From: Fairchild Fenton, Diane
Sent: 30 April 2020 16:28
To: _planningadvice
Subject: FW: Application reference.: H09-0311-20.

Subject: [EXTERNAL] Application reference.: H09-0311-20.

‘Two limbs require removal from large Oak tree (highlighted on map and pictures) these limbs are within the live zone of an open wire conductor.

91/2121 (21E0278)
HOLBEACH ST JOHNS

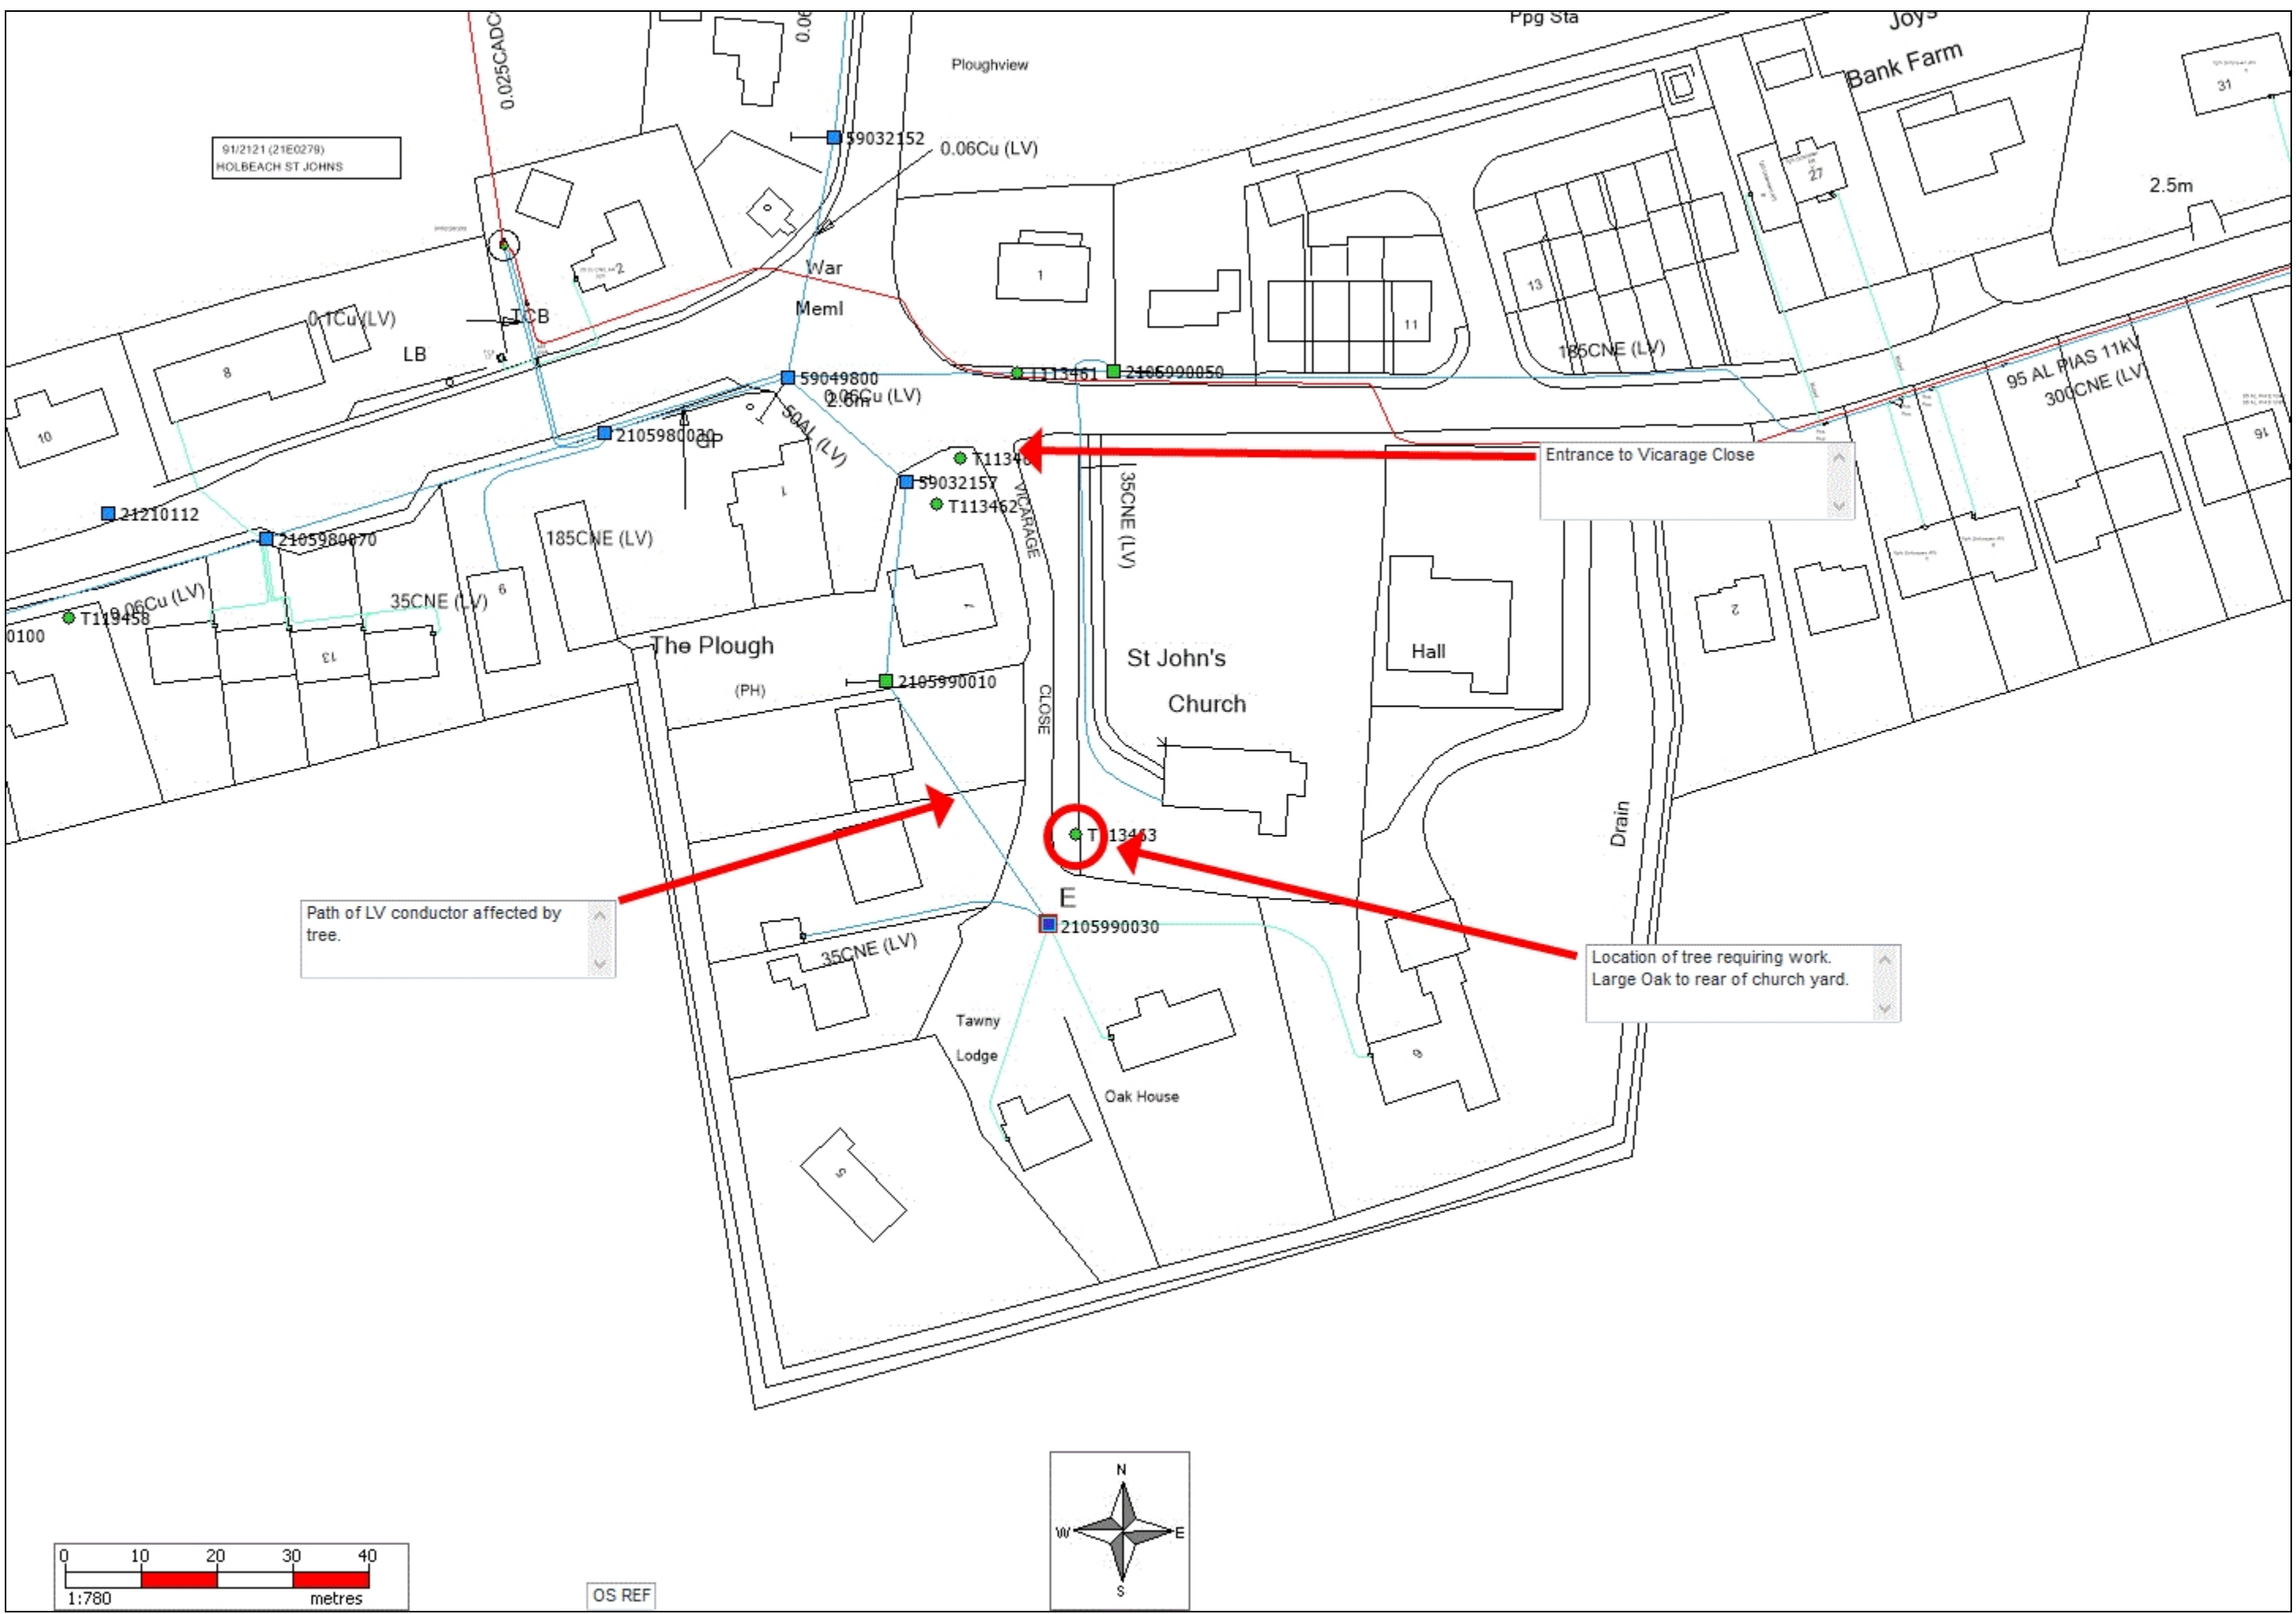
ENATS requires a 3 metre clearance for climbable trees to be around this live zone for safety reasons, these limbs are well within that limit, limbs within this proximity could potentially be live due to their location. All work would be done by qualified arborists who are utility arb trained and under shutdown conditions due to the danger of cutting so close to the conductor live work is not possible.’

Side Prune - Circles on drawing identify limbs not where to make cuts, clearances based on council guidelines TPO tree.

SPECIAL INSTRUCTIONS TPO TREE MINIMAL AS POSSIBLE CUTS TO PREVENT MAJOR WOUNDS ON TREE. CLEARANCE OF 1.5 METRE AROUND CONDUCTOR WITH TREE GUARD FITTED TO INSULATE LINE AFTER COMPLETION OF WORK. Advanced notice needs to be given
